**WELWYN HATFIELD ACCESS GROUP  
HAZEL GROVE COMMUNITY CENTRE  
HAZEL GROVE  
WELWYN GARDEN CITY  
HERTFORDSHIRE AL7 2DG**

***re: Planning Applications Received by Welwyn Hatfield Council***

<b>Application No.</b>	<b>Description and Location</b>	<b>Applicant/Agent</b>
S6/2013/1469/FP	Erection of single storey side and rear extension and two storey rear and side extensions and provision for additional parking  Oak Cottage Care Ltd Wilkins Green Lane Hatfield AL10 9RT	Mrs P Batchelor 34 Claudian Place St Albans Hertfordshire AL3 4JF

Proposed Ground Floor

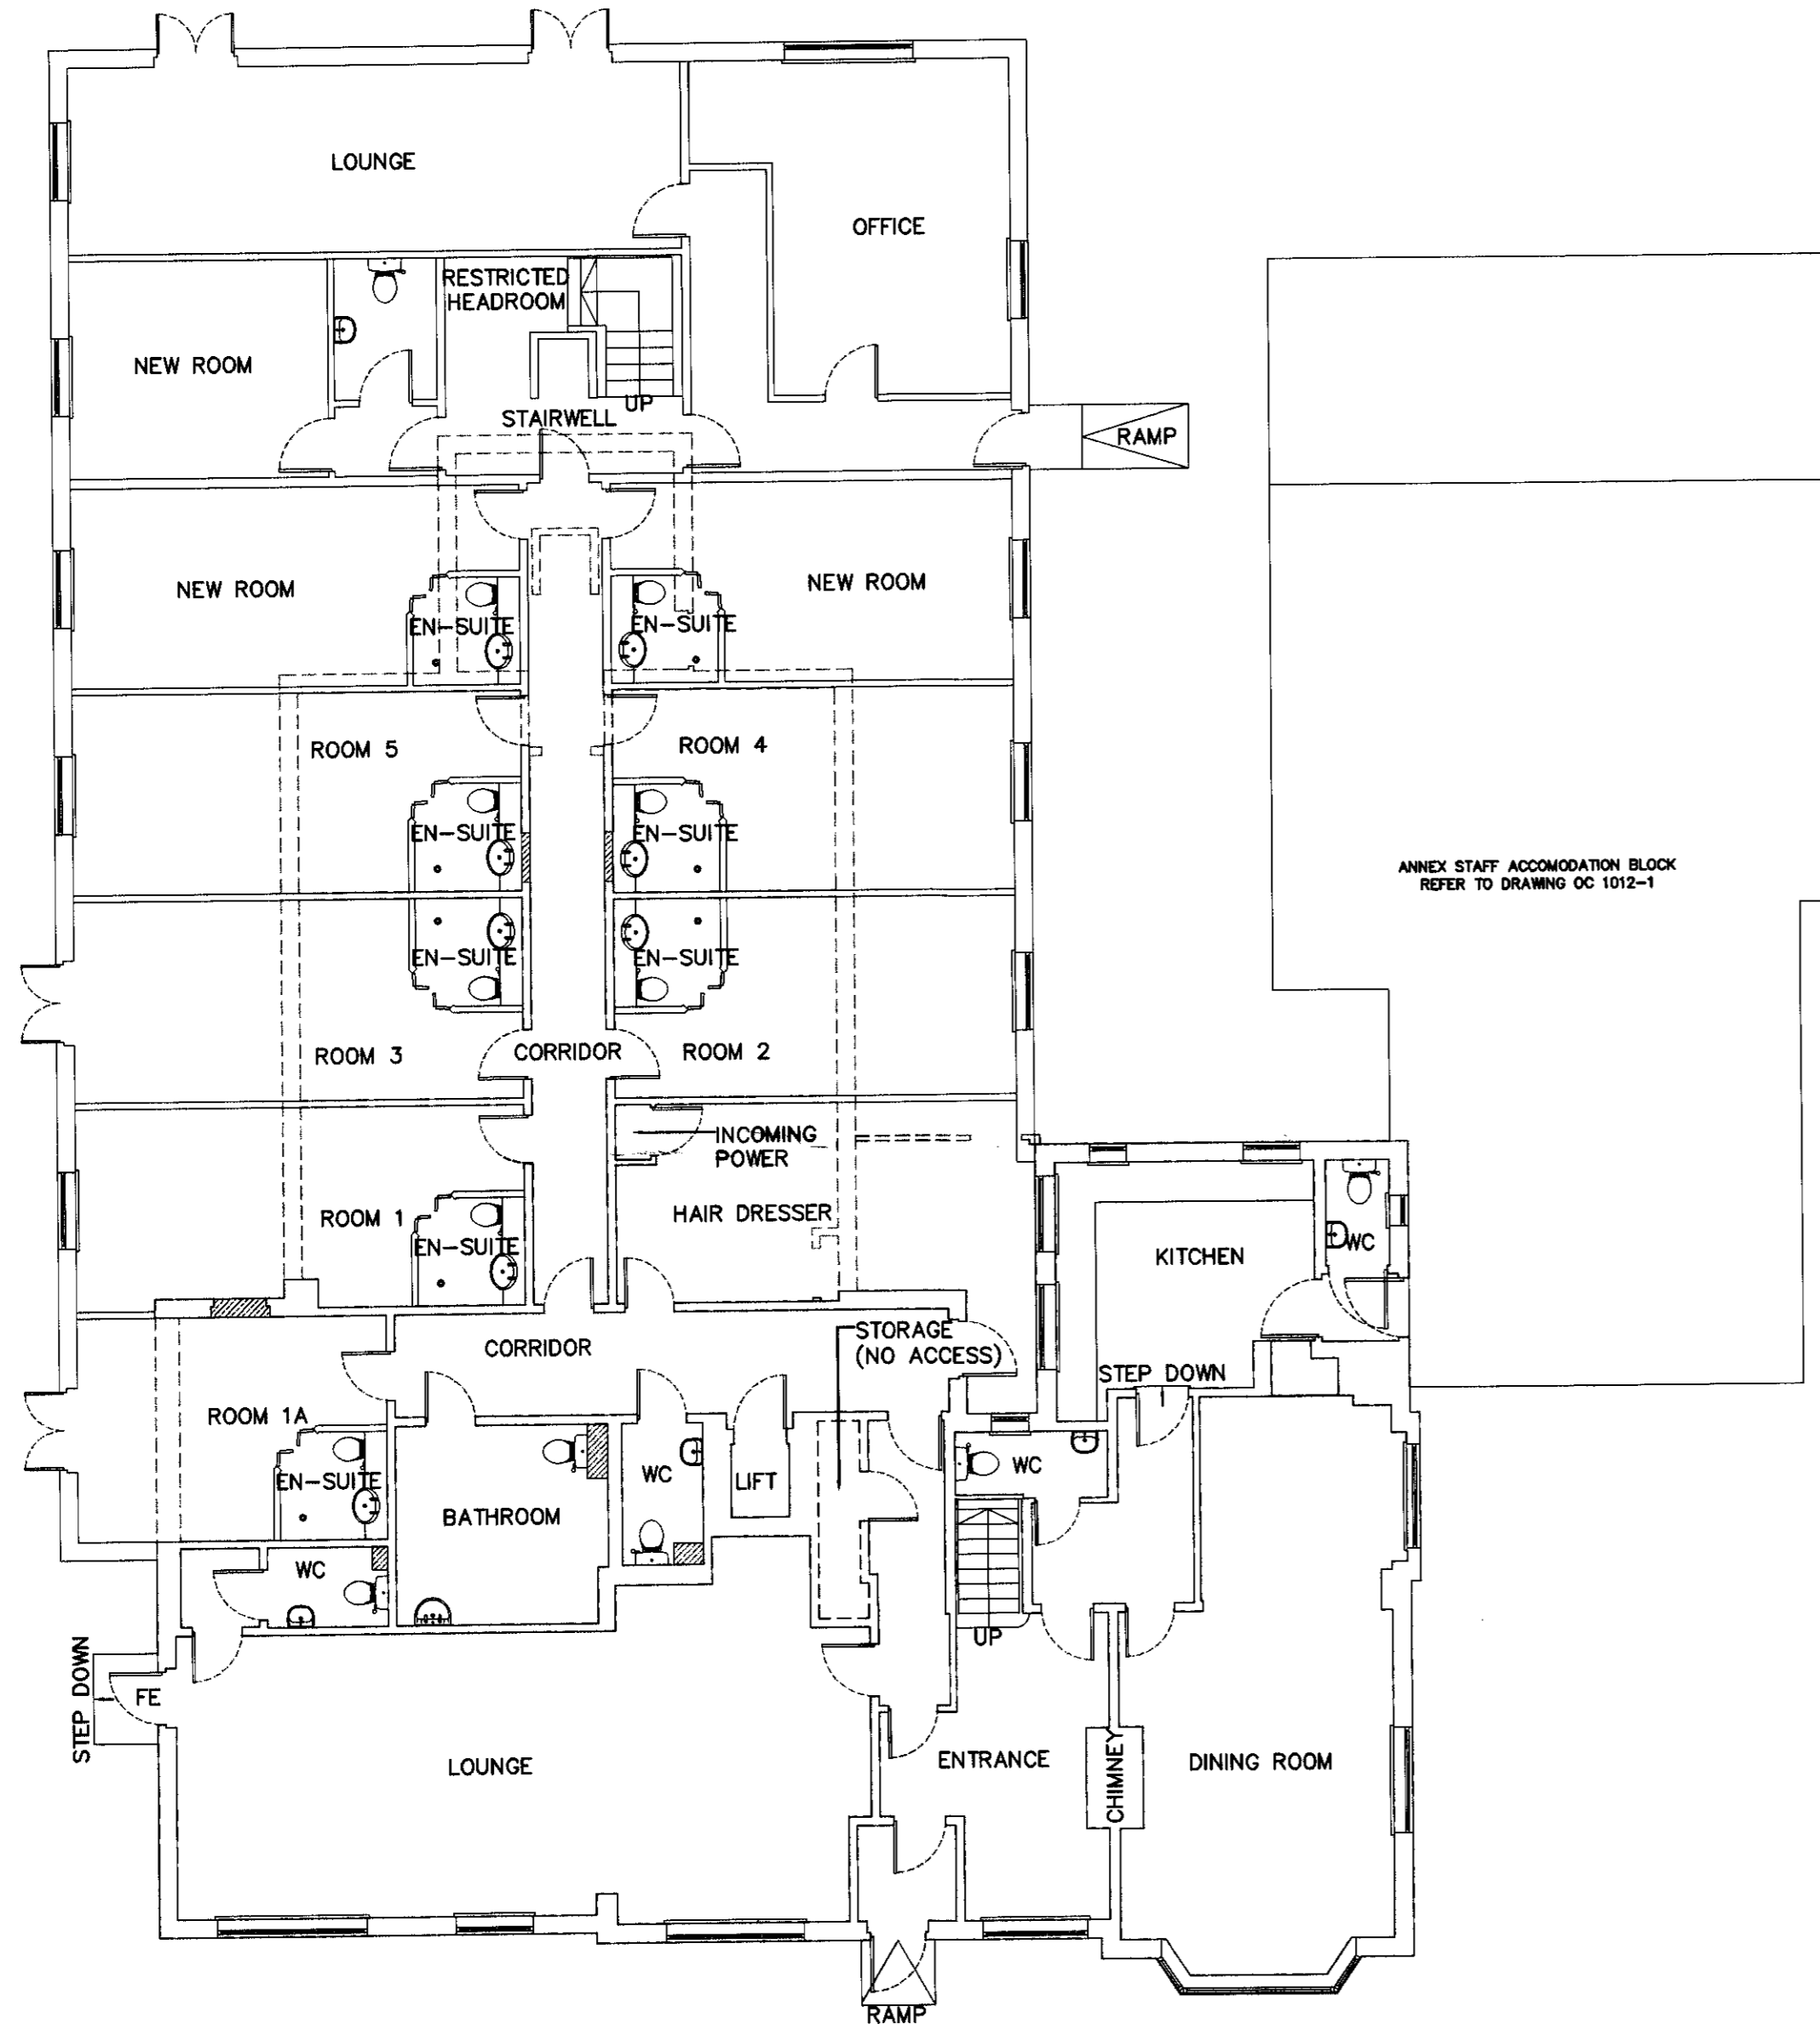
We note the pedestrian access ramp at the principal front door. We also note the location of the public toilets in the main building, which appear to be wheelchair accessible. Do they fully comply with Part M guidelines?

Having asked that question can you advise if there is table service in the dining room or does need collecting from the kitchen area as the step is a potential access hazard. Furthermore, the toilet in the kitchen area appears to be wheelchair accessible. Please confirm the situation.

Proposed First Floor

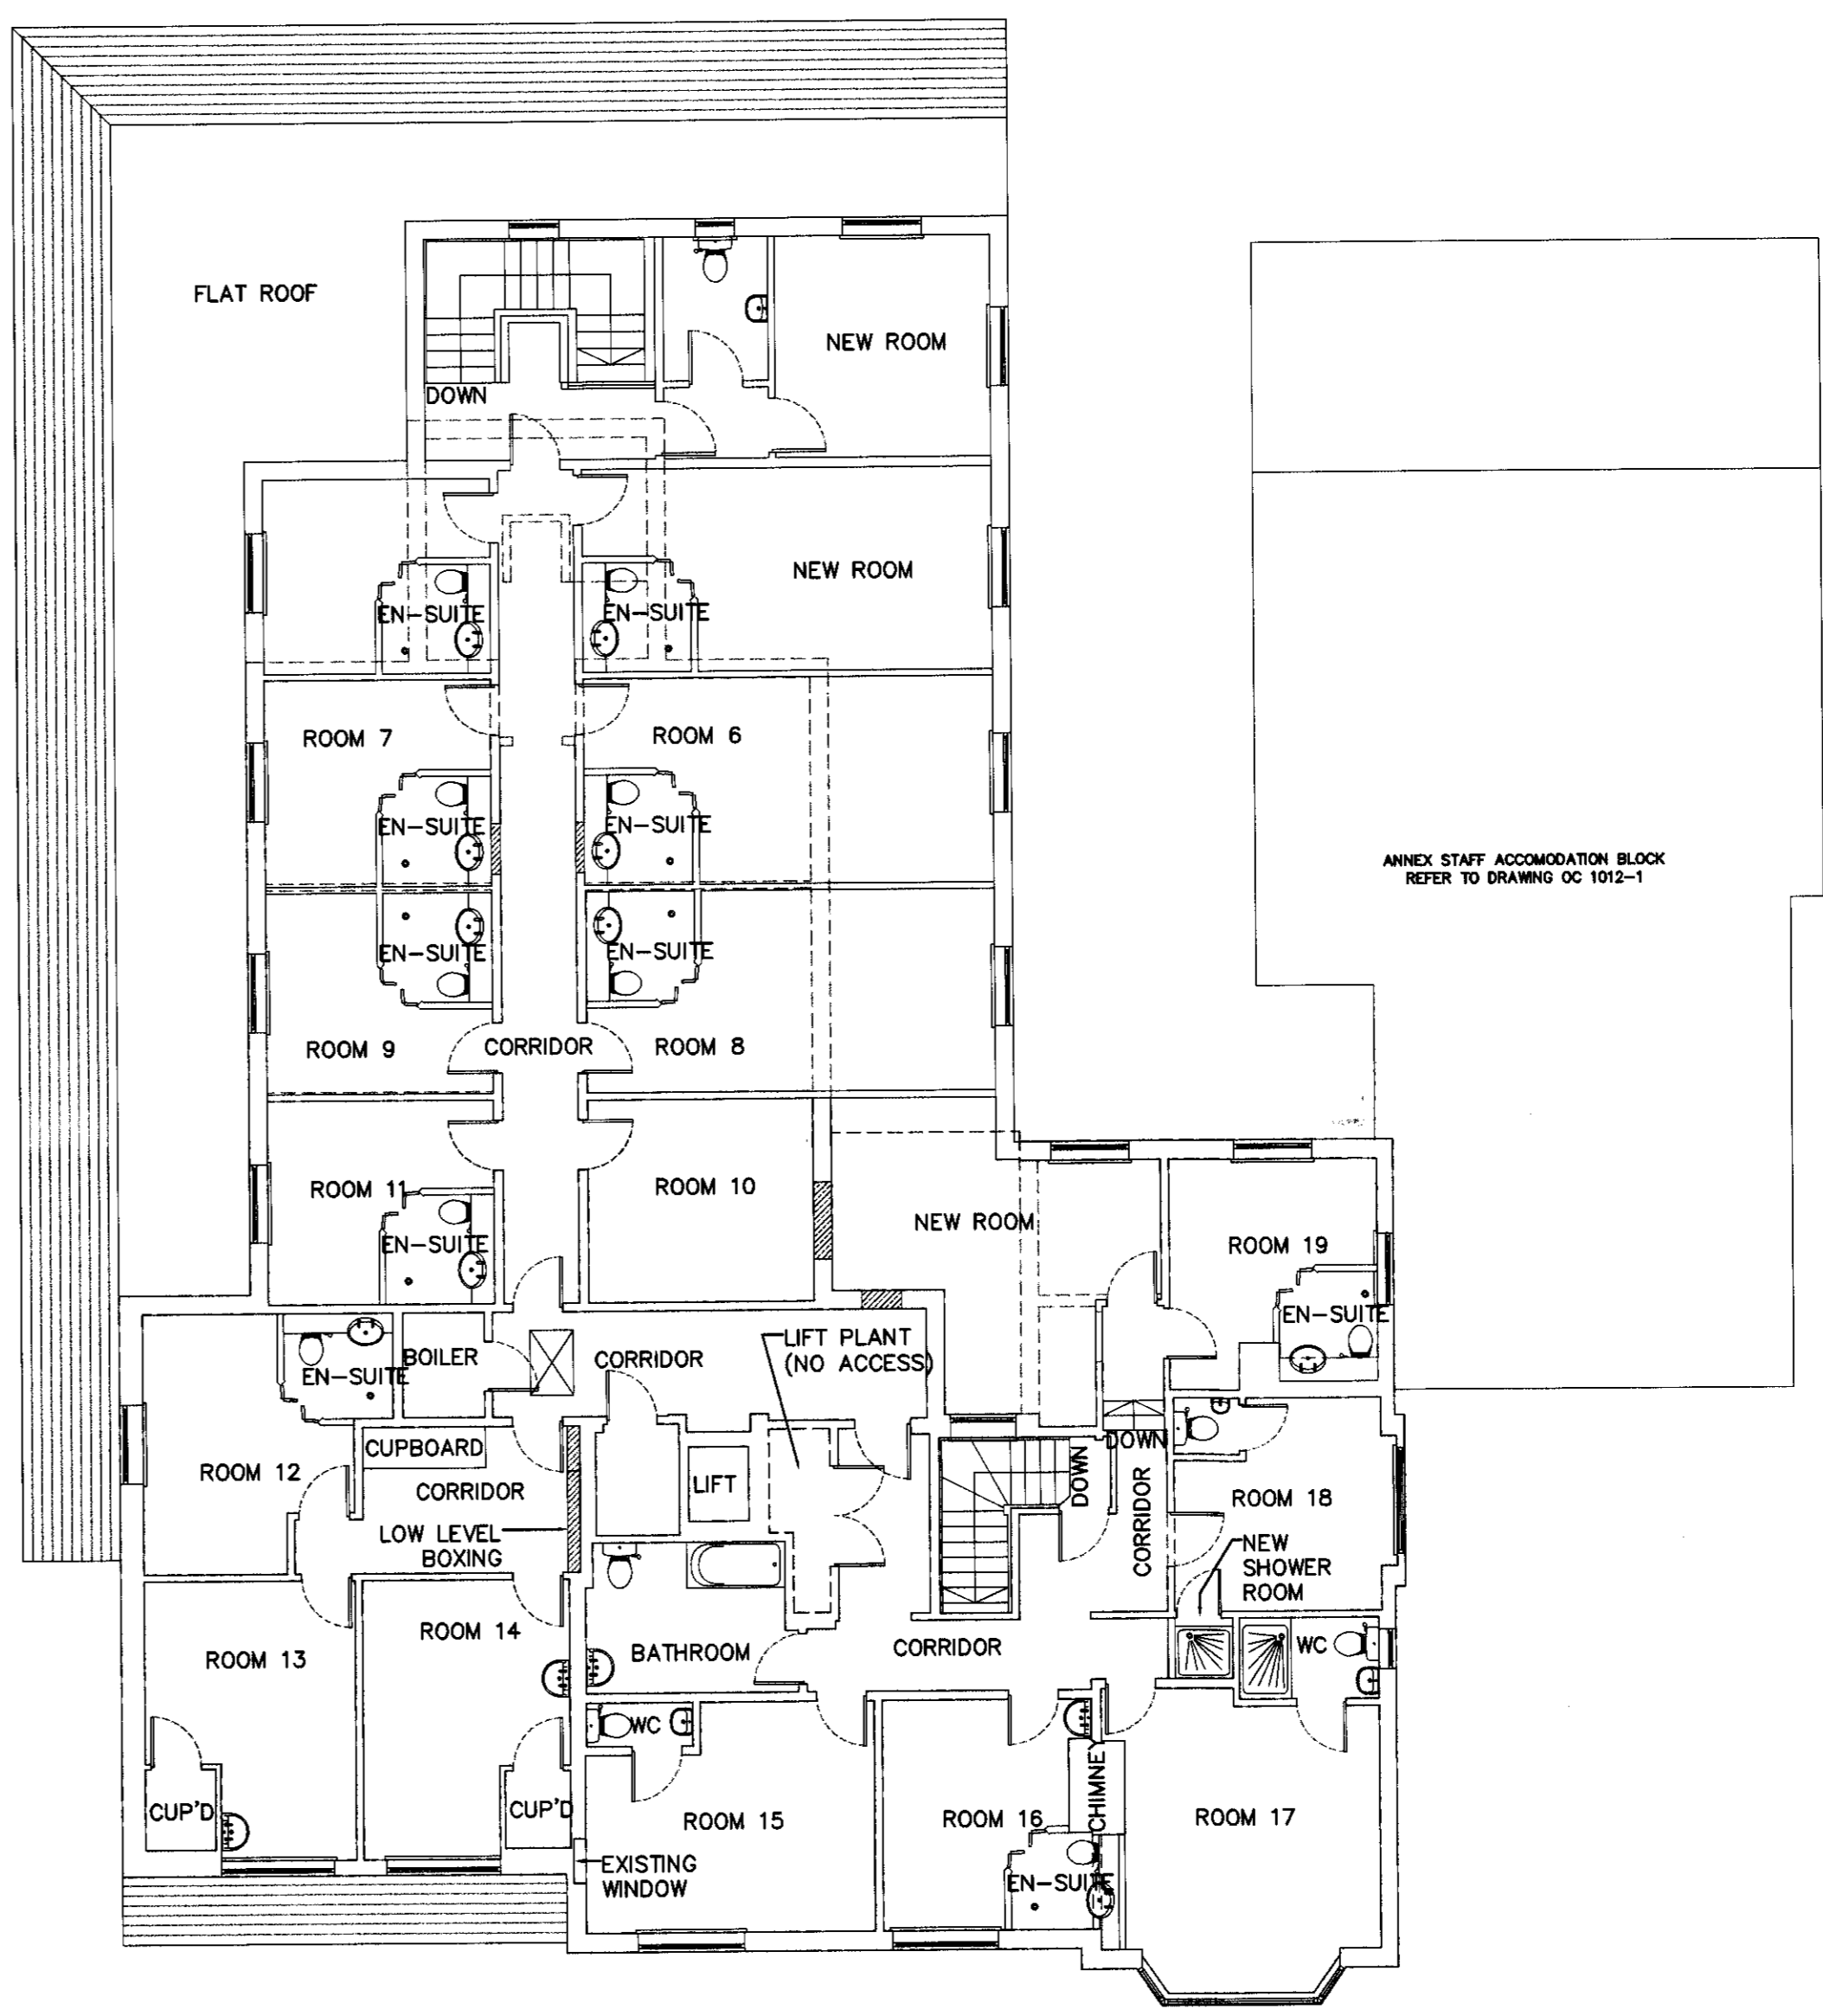
We note the details provided by this drawing. Could you confirm if the passenger lift is to evacuation standards? If not, are there any refuge places and do they comply with BS9999? In fact, what emergency egress provisions are there for those first floor residents?

TITLE	
Proposed Elevations North & South	
PROJECT NAME	
Oak Cottage, 4 Wilkins Green Lane, Hatfield, AL10 9RT	
DRAWN BY	DATE
	SEPT 2013
SCALE	CHECKED
1:100 @ A3	
DRAWING NO.	REV. NO.
EL/2012/07	E

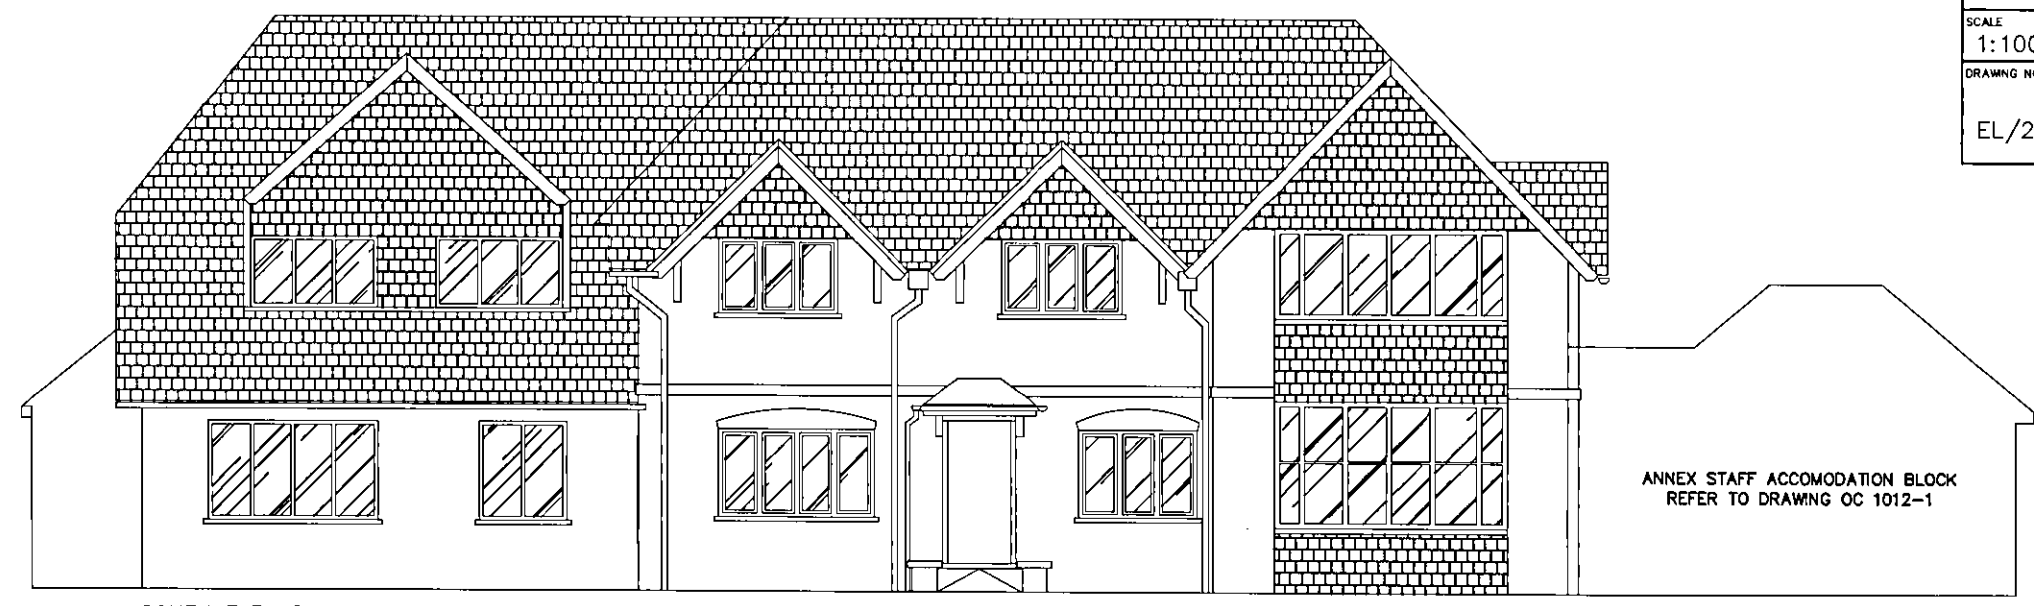
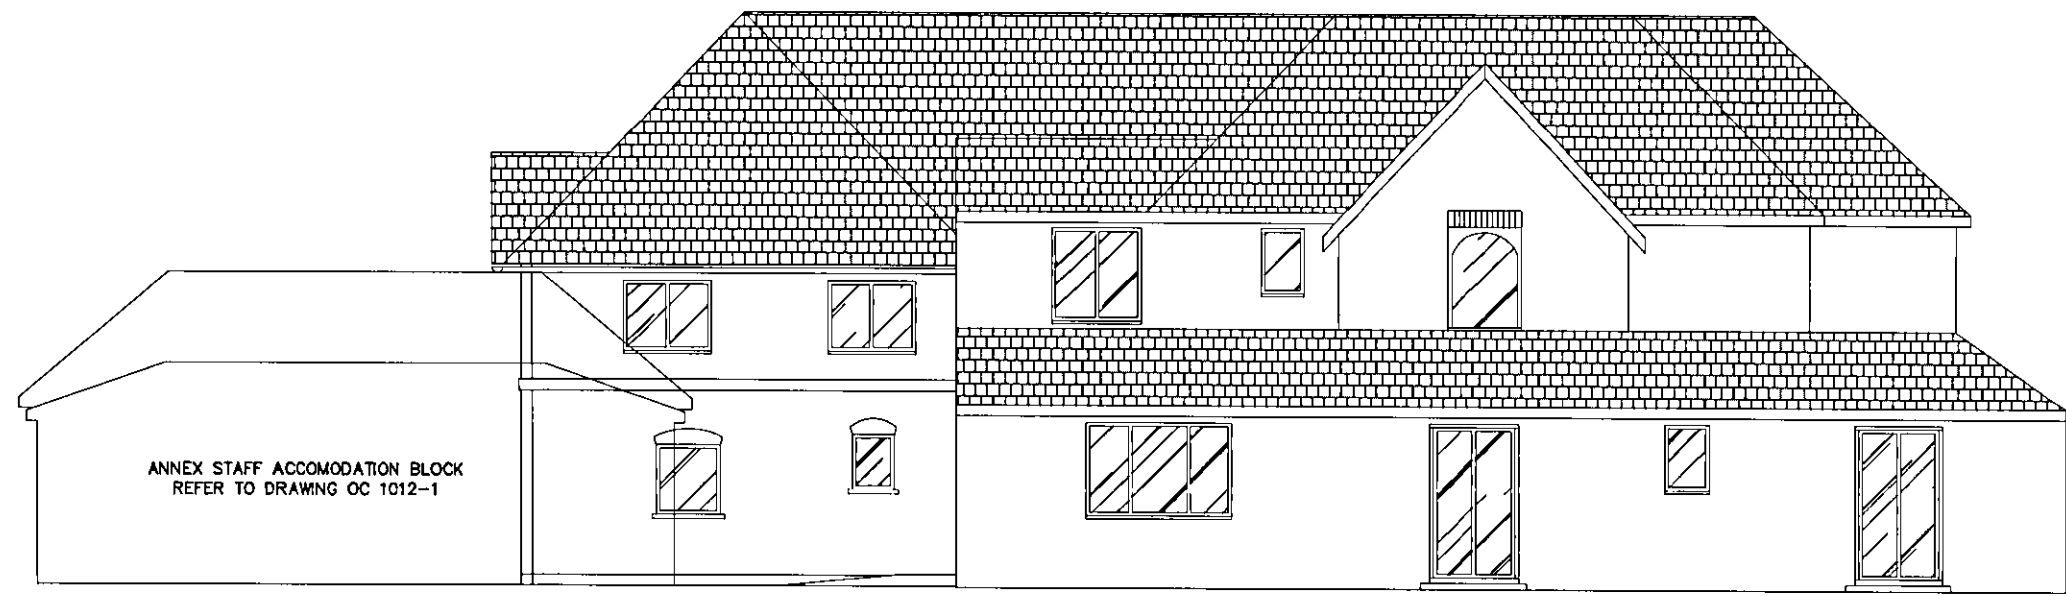
We note the details provided by this drawing showing there is stepped entry at all doors. This is not appropriate for wheelchairs and limited/impaired mobility persons and should in our opinion be changed to level entry especially as some, if not all, may double as fire exits.
